Please find attached an amended drawing containing the changes that you have requested – (1) removing the rear projection so that the entire garden depth is 8.5m, (2) removing the rear dormer window to Bedroom 1 replaced with 2no. roof-lights at 1.5m height in order to ensure no possibility of overlooking, and (3) and very modestly enlarging the front elevation in line with your comment.

Heathers Arundel Road Angmering BN16 4LE

P3	25.10.19	Revised notation.	JT	AK
P2	25.10.19	Revised red line and road name correction.	JT	AK
P1	17.10.19	Planning Issue.	JT	AK
Rev	Date	Revision Details	Dr	Ch

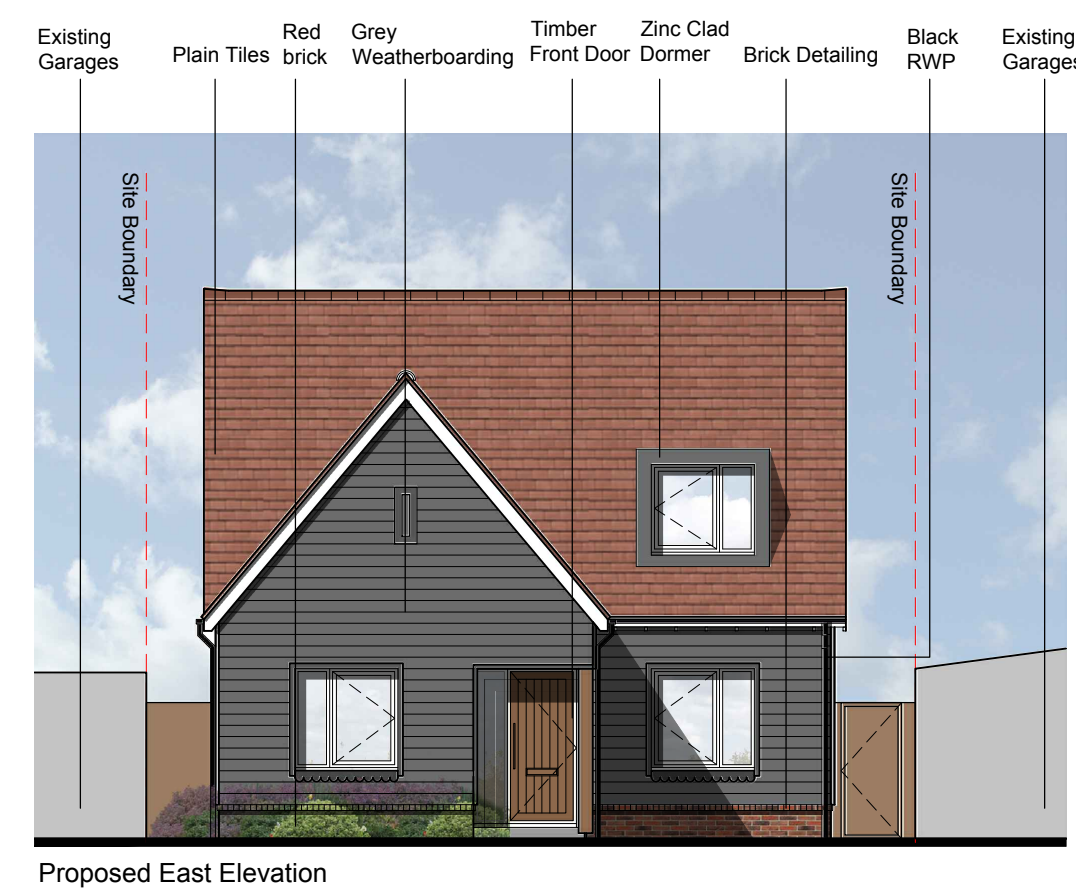
I had a chat here internally and we feel the proposal could be ok, on balance once a few changes are made. I mentioned your willingness to make whatever changes we felt necessary to get it over the line. Could you send in an amended plan removing the rear dormer (replacing it with a rooflight) and squaring off the rear elevation so that the rear garden depth would now be 8.5? If you wish you could slightly enlarge the dwelling at the front elevation to get back some internal space.

A rear garden of 8.5m in depth at maximum and 6.3m for the majority is less than what's recommended. As I'm sure you know 10 or 11m is looked at as a minimum depth. Although the principle of development is ok other issues such as above and the hemmed in nature of the proposal in relation to the rows of garages on either side are likely to be other issues for this proposal. I will have a closer look at 'Red Admiral Bungalows' and if possible visit this site when on site next week.

Your suggestion and willingness to make further amendments to the proposal in terms of the rear gable end and rear facing dormer window are also noted. However before I ask you to make any amendments I would like to carry out that site visit to see if this is what's needed to bring the proposal to a positive conclusion.

A point made in one of the letters was that there is a 1.5m drop from one end of the site to the other. If so a skyline plan showing how the proposed would look in relation to other nearby dwellings/ bldgs. would be helpful.

We will provide an updated drawing showing the amendments to the garage to turn it into a car port, so will send this over soon.

In this regard, we do have the option (whilst I do not believe it to be at all necessary due to the separation distances involved and the chalet nature of the property), to amend the ground floor gable window to a standard door/window set, removing

the triangular glazing, and also to amend the dormer window to Bedroom 1 and replace this with a roof-light if you consider these as requirements to secure a positive recommendation.
